**STATEMENT OF ENVIRONMENTAL EFFECTS: SECTION 75W APPLICATION, MODIFICATIONS
TO MAJOR PROJECT MP NO.10_0158 (BUILDINGS 7 & 8) – 61 MOBBS LANE, EPPING**

Pursuant to Section 75W (1) (a) of the Environmental Planning and Assessment Act 1979, a 'modification of approval' is sought to vary Condition No. A2 pertaining to Major Project MP No. 10_01581 (Buildings 7 & 8) as approved on the 12 July 2011. The modification is to amend architectural plans to accommodate minor design changes.

1 BUILDING 8 GROUND FLOOR PLAN
1:100

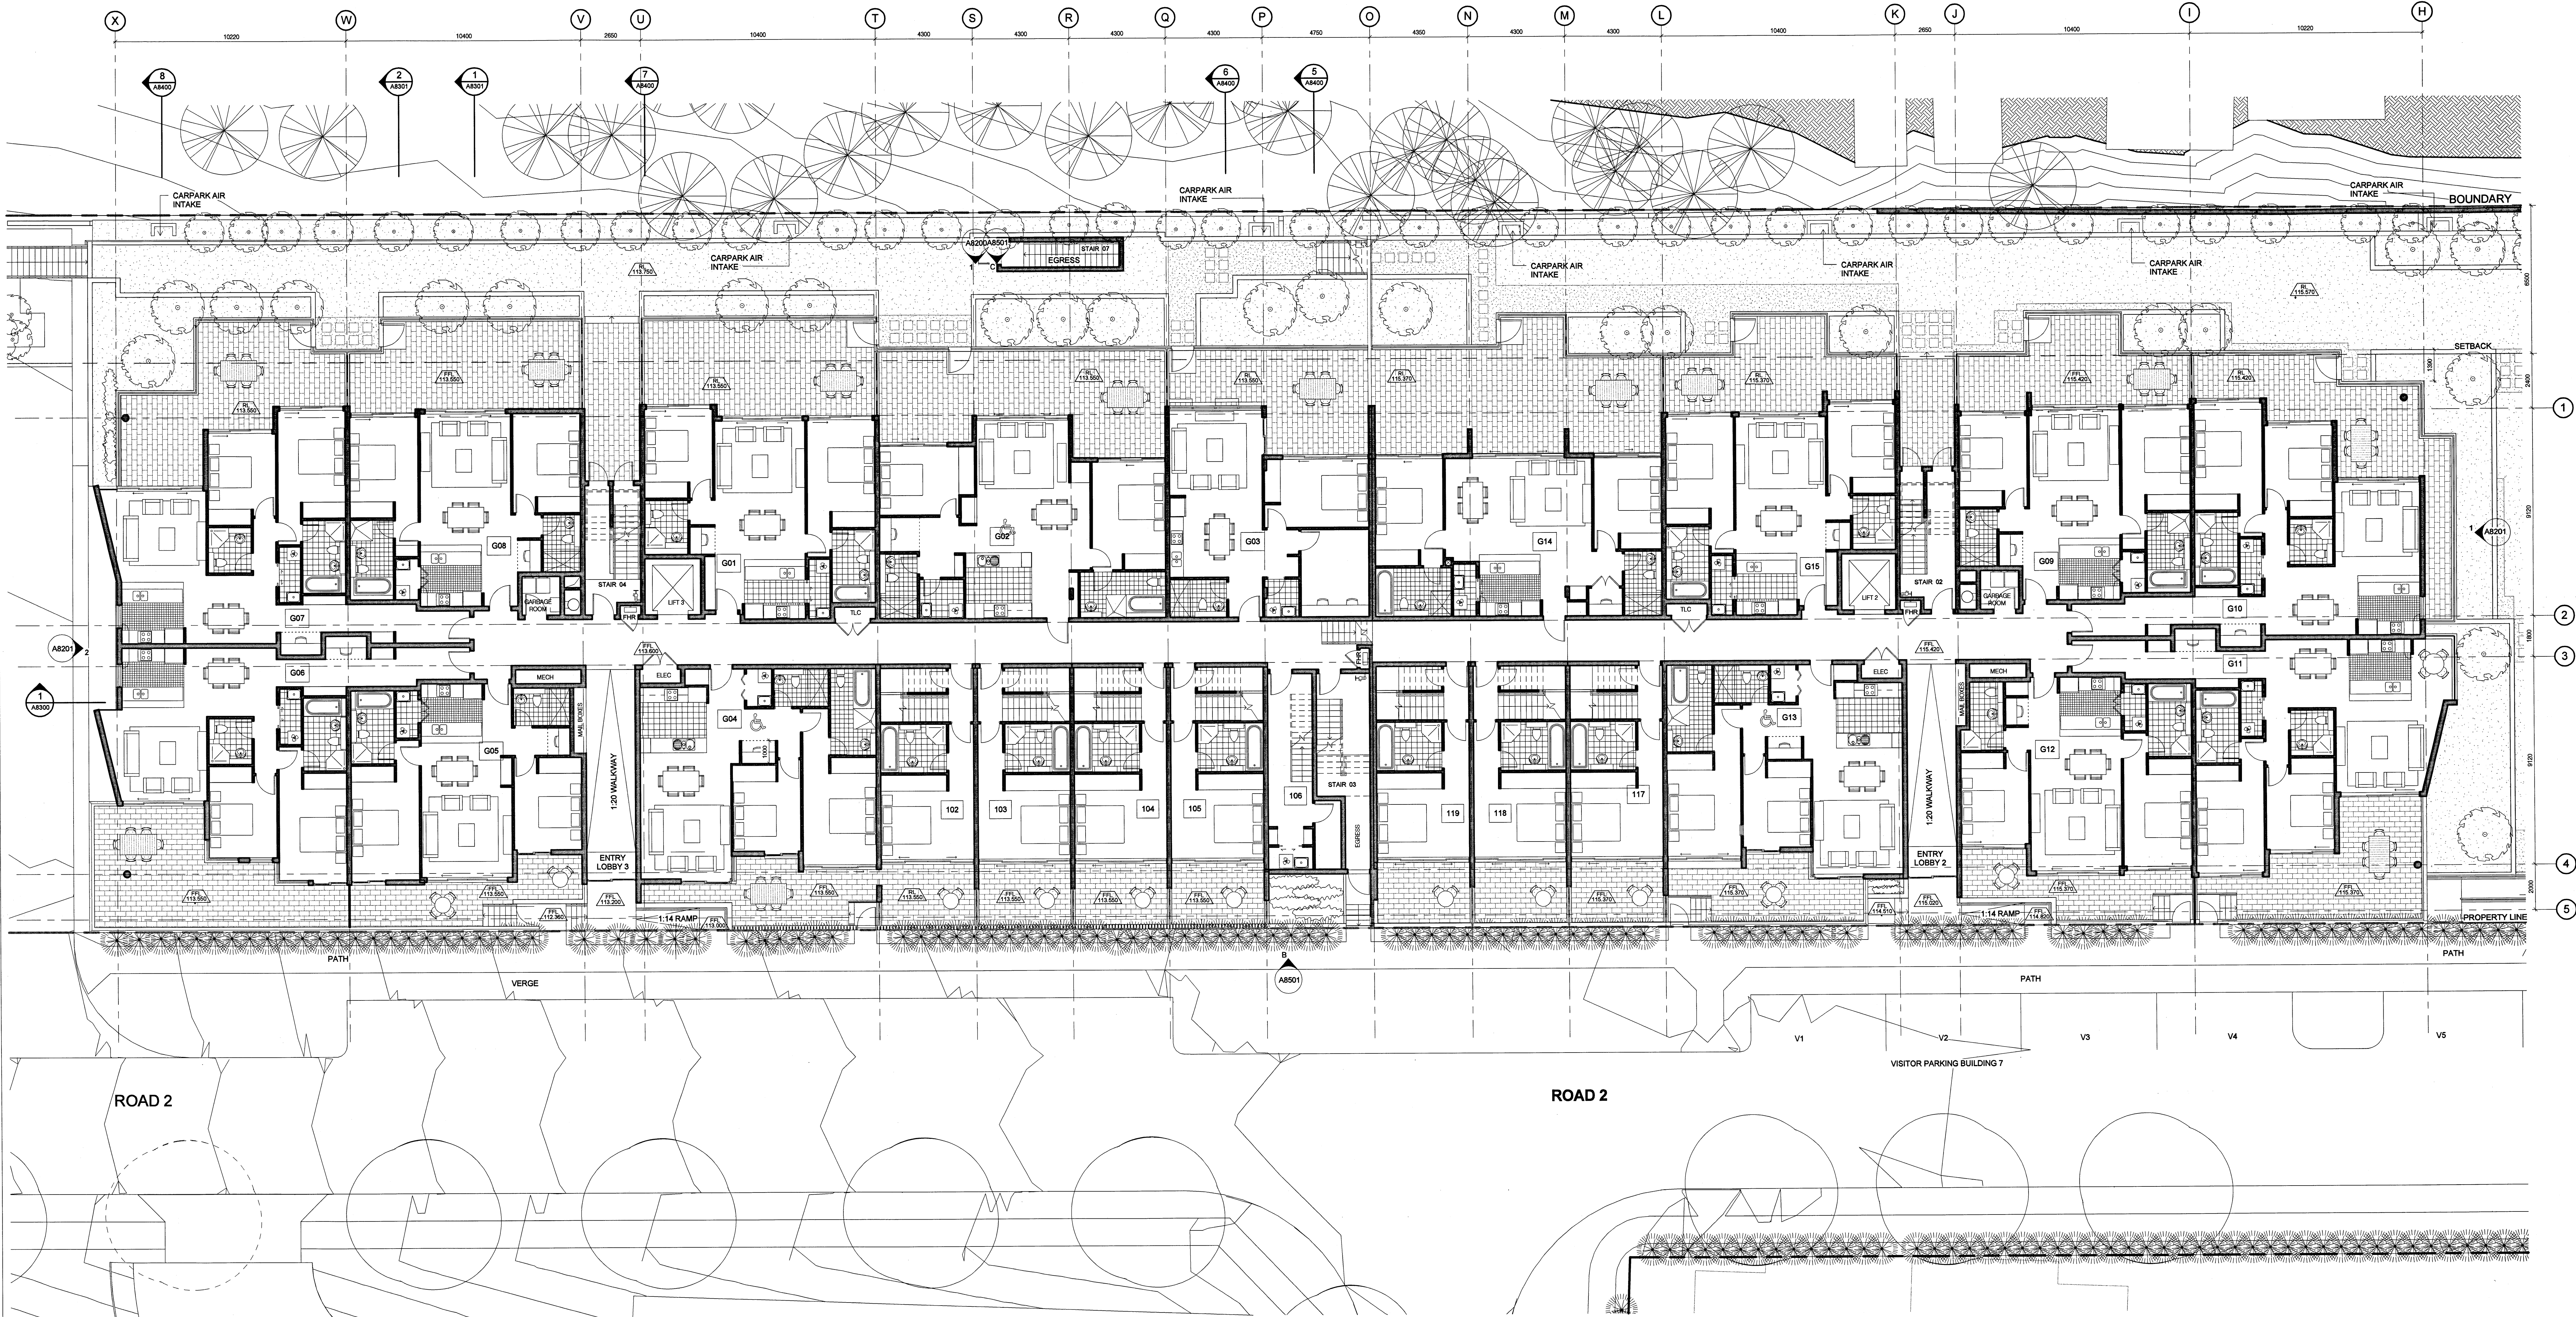
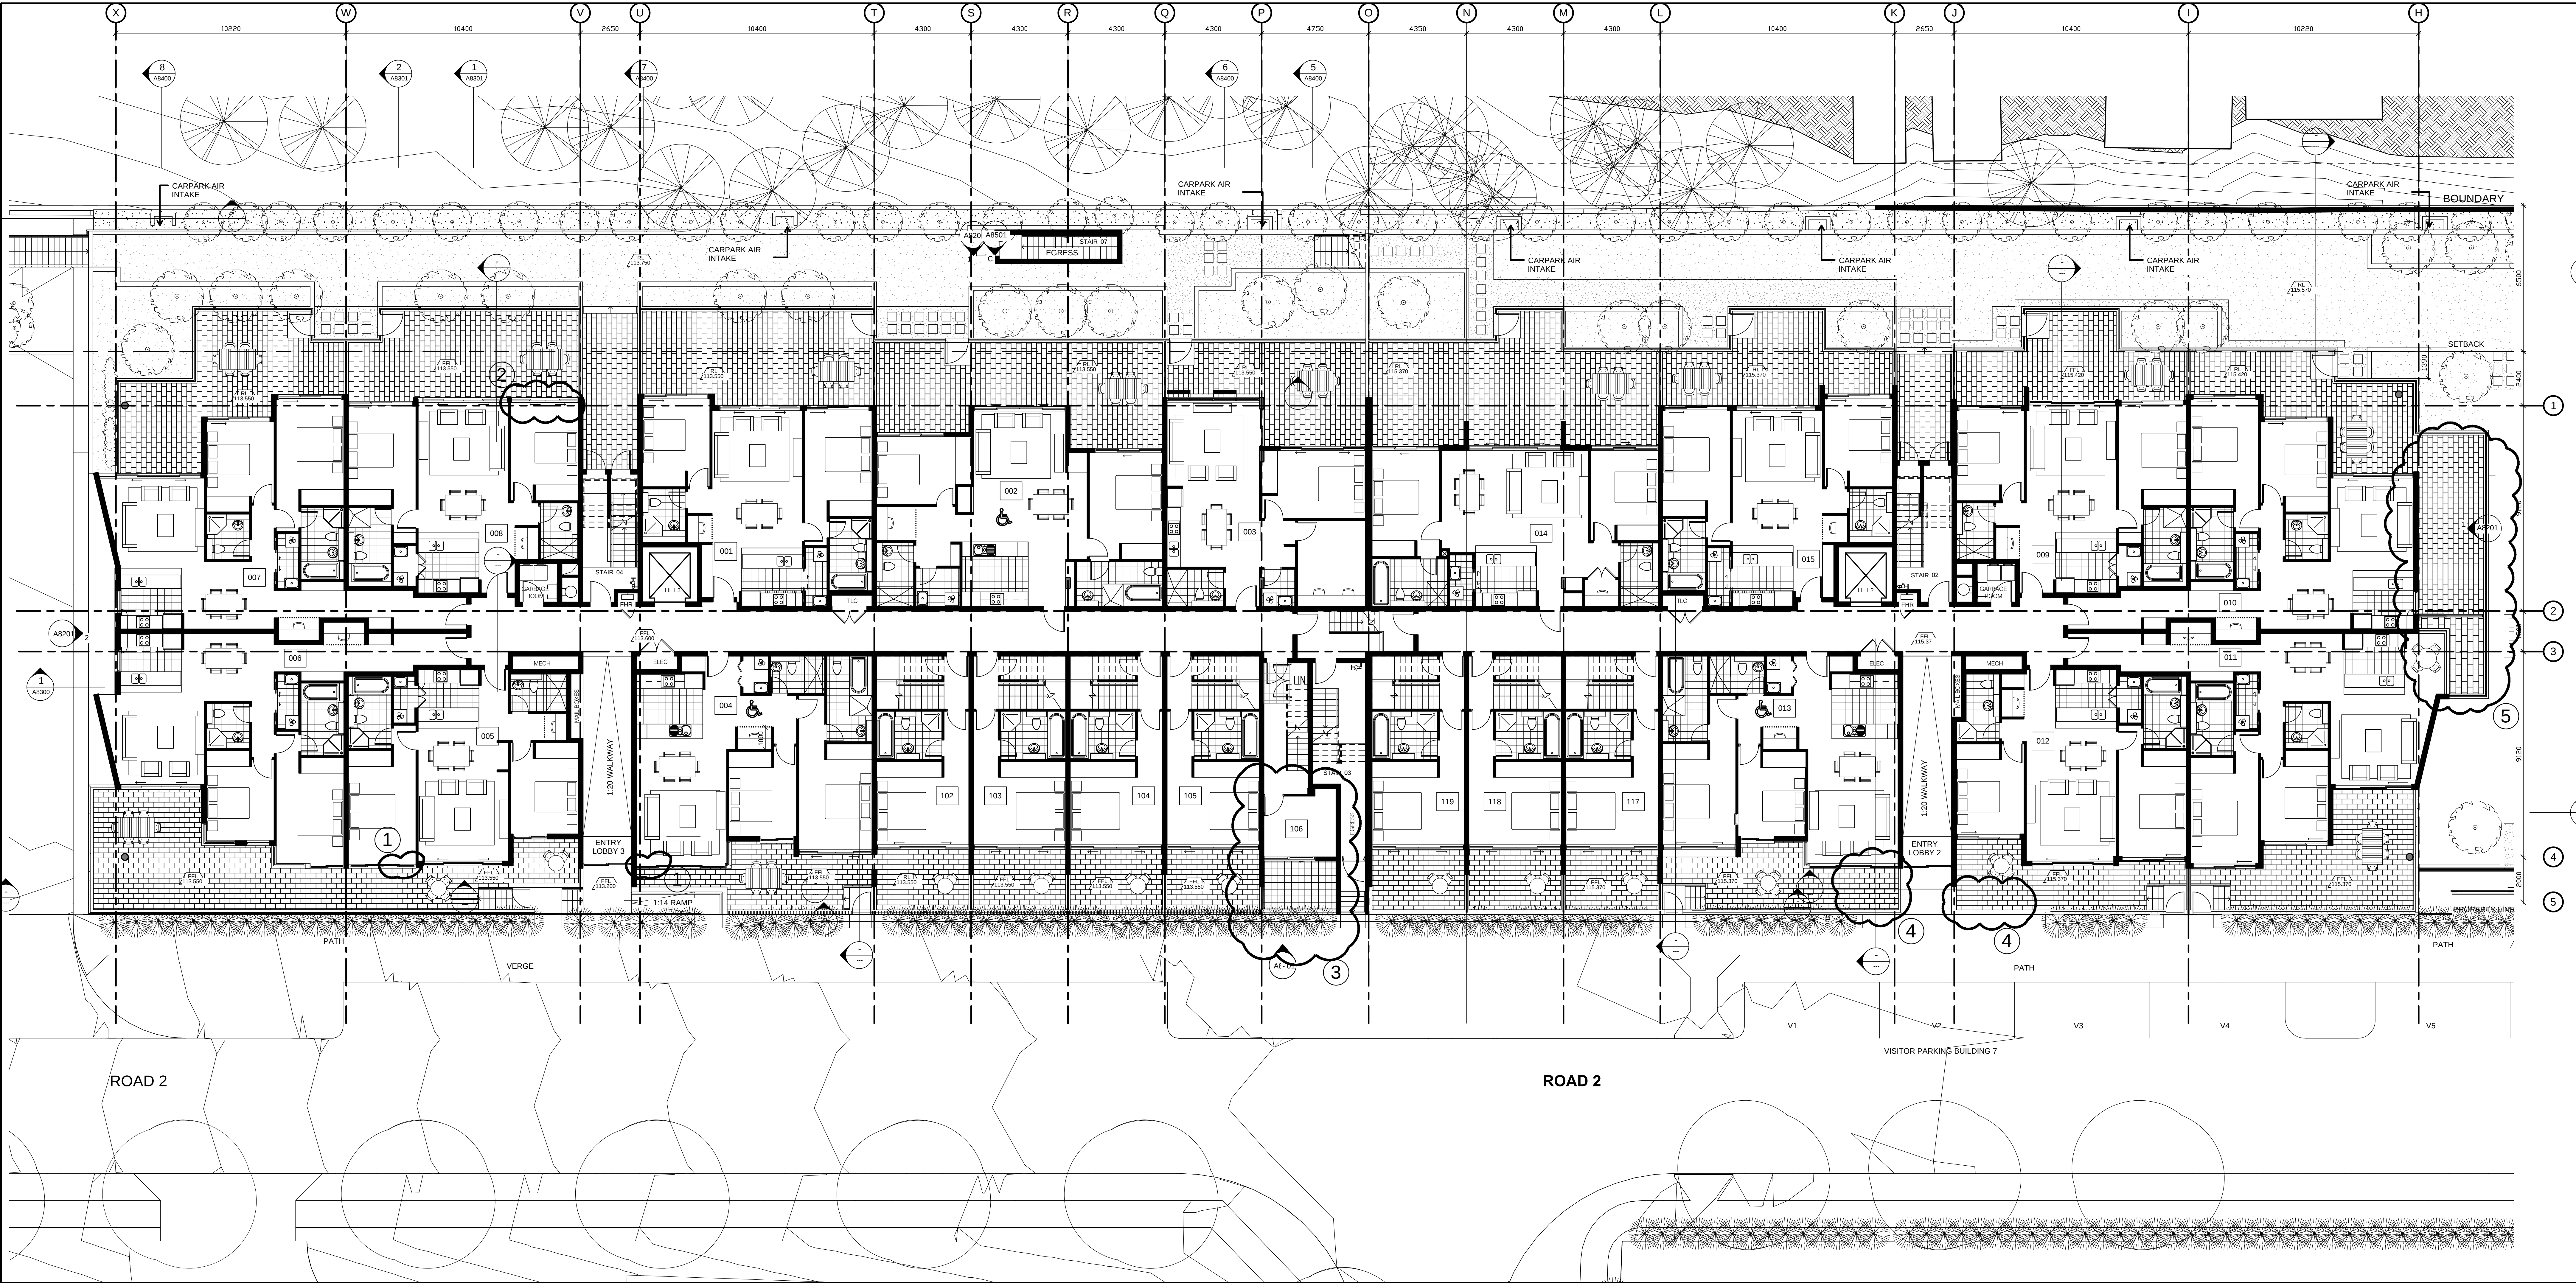
With reference to Point 3, modification to unit 108, additional detail is provided below:

Existing Approval	Proposed Modification
Ground Floor Plan, A8103 Plan shows laundry and solid wall to the south. Given the solid wall the existing garden area is currently inaccessible.	Ground Floor Plan A8103, Rev A Laundry is converted to a study. The solid wall is opened up and has a sliding door. Allowing light and ventilation into the study area. The garden area has been converted to a tiled courtyard which is consistent with the surrounding units and allows that space to be used as a functional courtyard. Previously it was inaccessible. It also provides an aesthetically pleasing recreational space for future residents.
Level 1 & 2 Plan, A8104 The bathroom, kitchen and dining area is configured in a 'square' layout.	Level 1 & 2 Plan, A8104, Rev A The laundry is now relocated to the first floor and the bathroom, kitchen and dining areas have been reconfigured to provide a more useable layout.
